Reference No:	2023/62/91419/W
Site Address:	30, Wadsworth Fold, Lindley, Huddersfield, HD3 3NB
Description:	Raising of roof and insertion of dormers to form 2nd floor bedroom
Recommending Officer:	Laura Yeadon

DECISION – CONDITIONAL FULL PERMISSION

HOUSEHOLDER DELEGATED REPORT

| drawing     | PROPOSED PLANS AND ELEVATIONS                           |             |       |

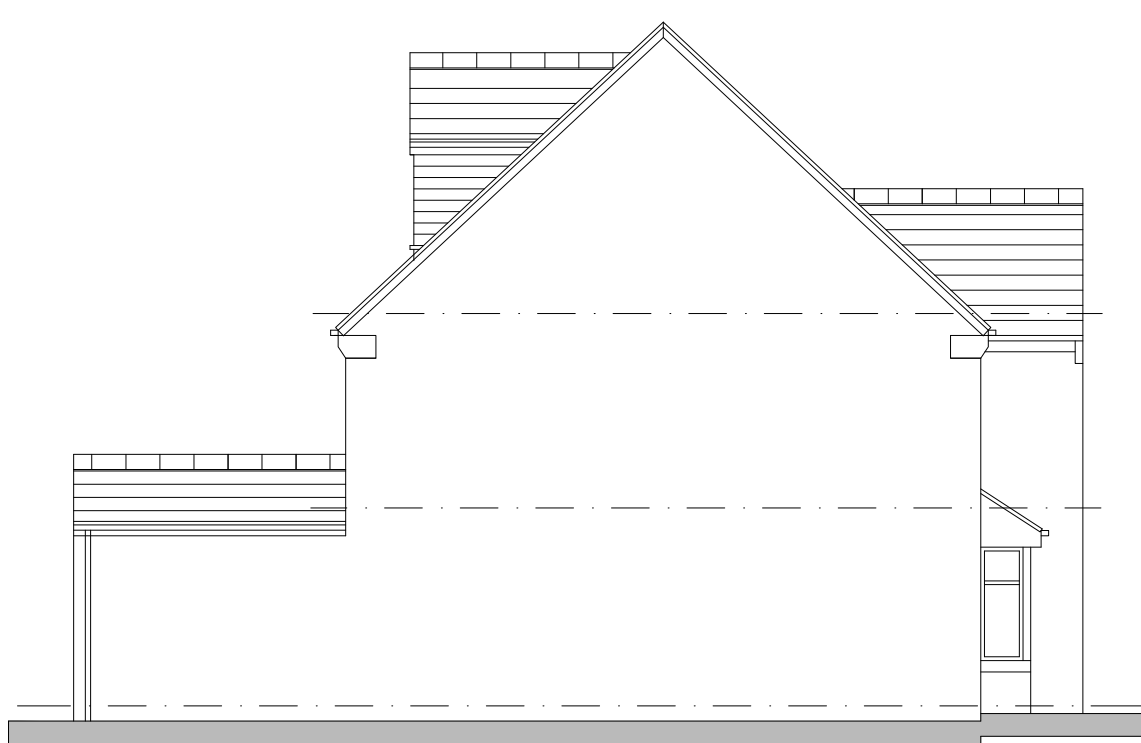
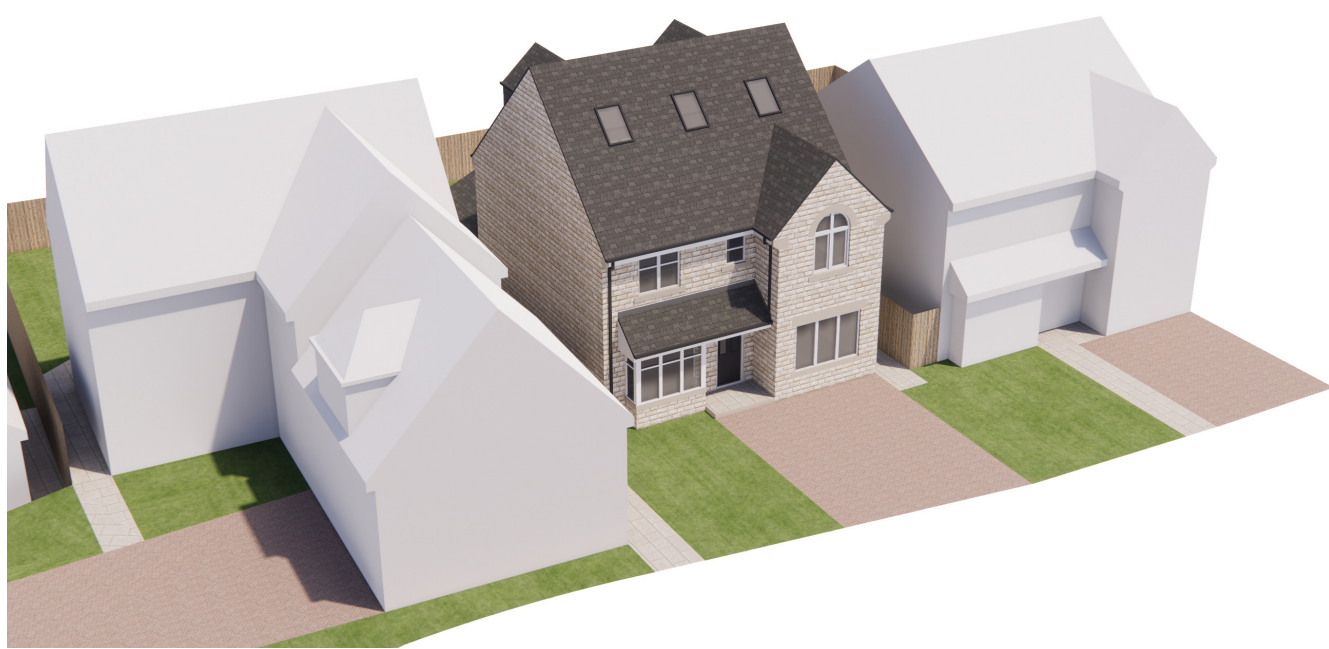
It is proposed that two dormer extensions would be located within the rear elevation roof slope. It is proposed that the dormer extensions would be identical in size, set up from the gutter line by 1.2 metres, set down from the roof ridge by 0.5 metres being a total width of 2.2 meters each.

The plans indicate that the dormer would be tile hung however there is no annotation on the plans. This can be conditioned.

4. The hereby approved dormer windows shall be either vertically slate hung with slates that in all respects match those used on the existing roof or be clad in dark grey cladding. The materials of construction shall thereafter be retained.

ATTIC FLOOR PLAN

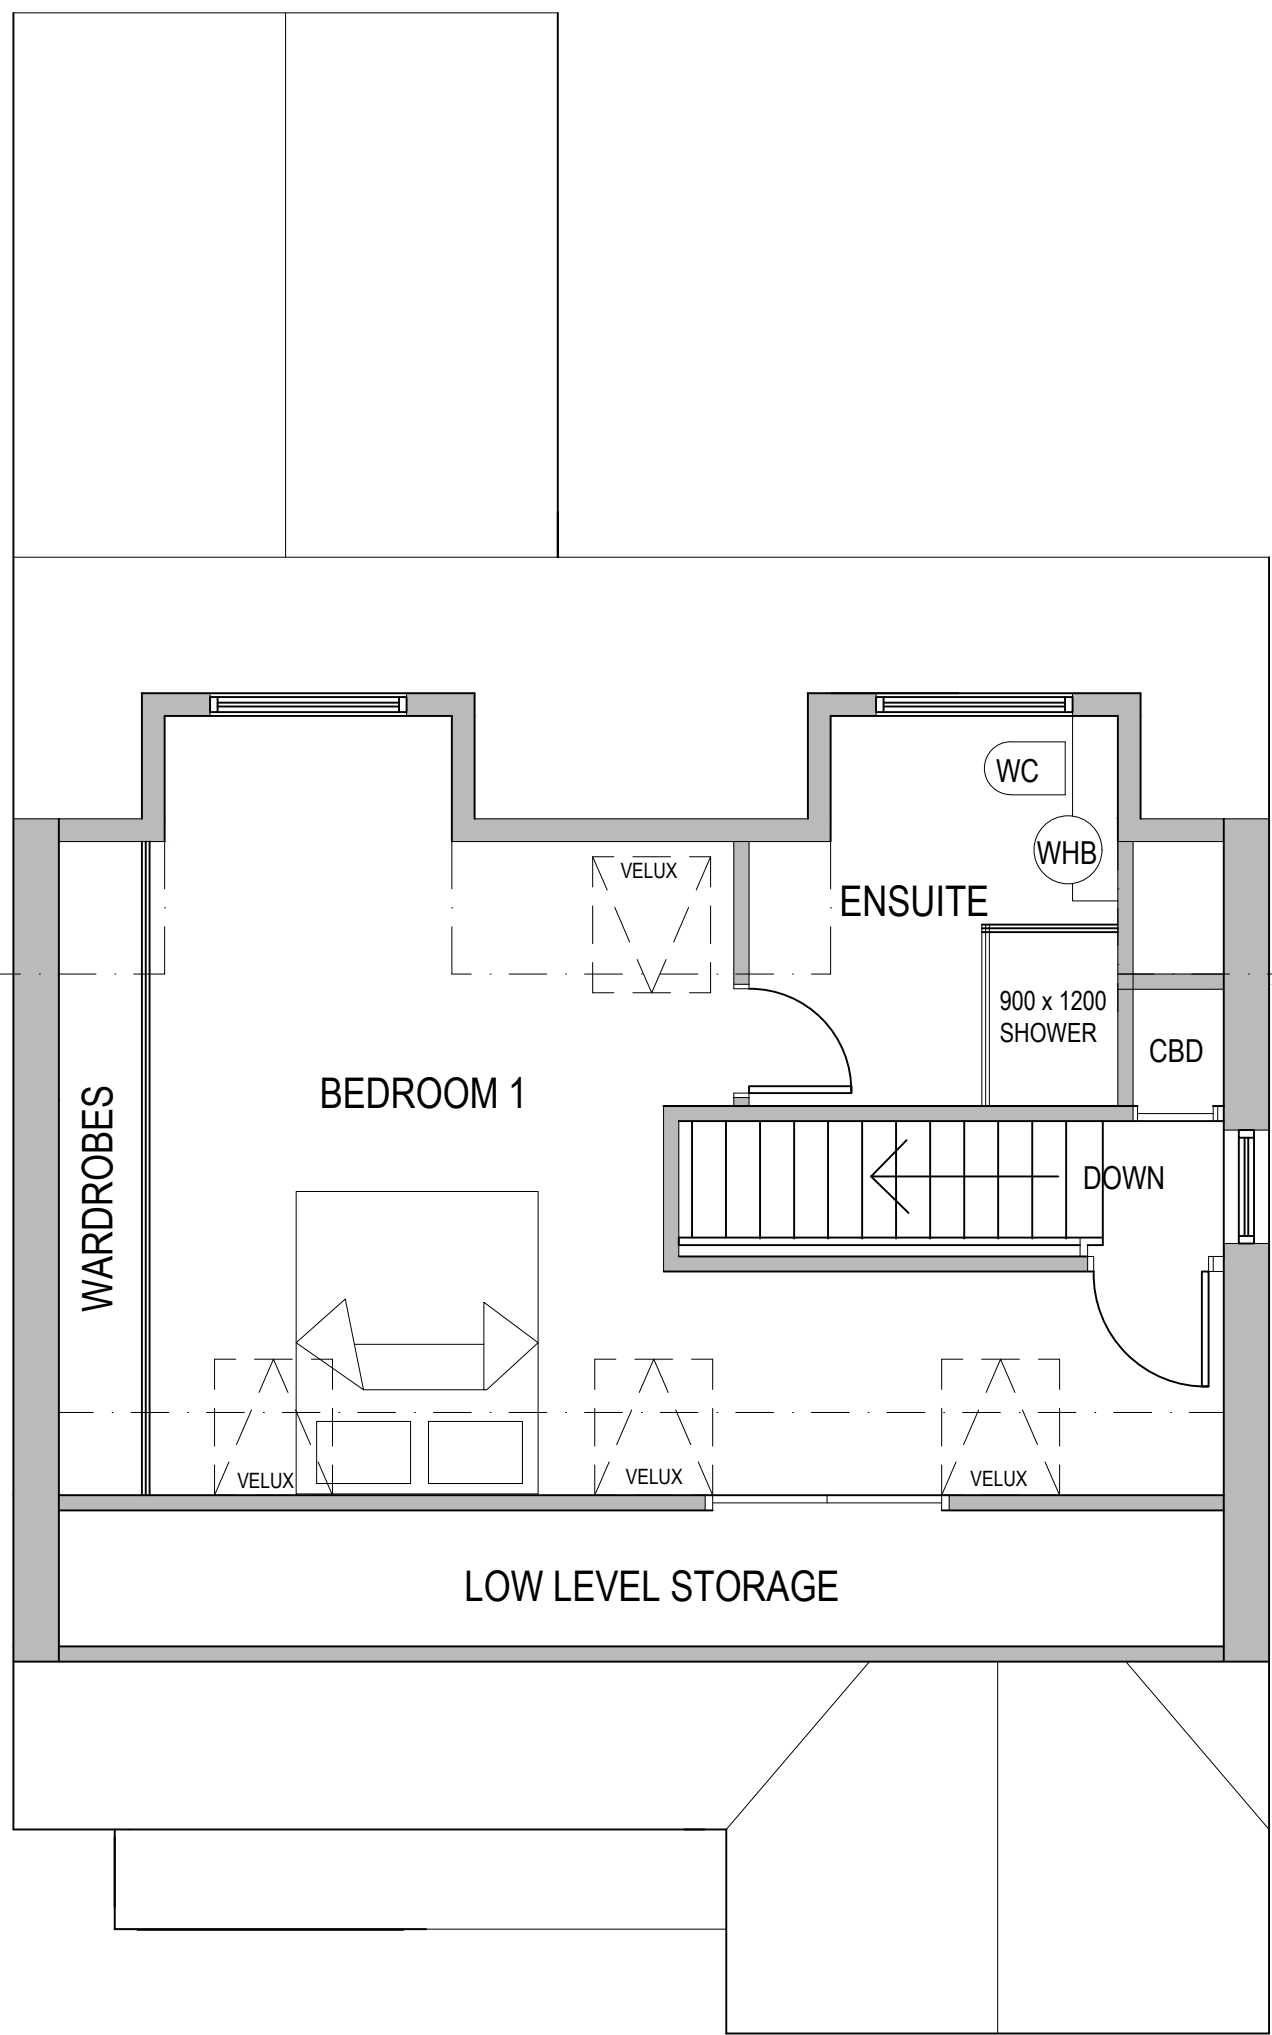
The application seeks permission for raising the roof and the insertion of dormers to form 2nd floor bedroom. It is proposed that the eaves height of the property would be retained at a height of 4.9 metres and it is proposed that the ridge of the property would be raised from 8 metres to 9.3 metres. It is proposed that the roof tiles would match the existing. 3 no. roof lights would be located in the front elevation of the roof slope and one 1 no. roof lights would be located.
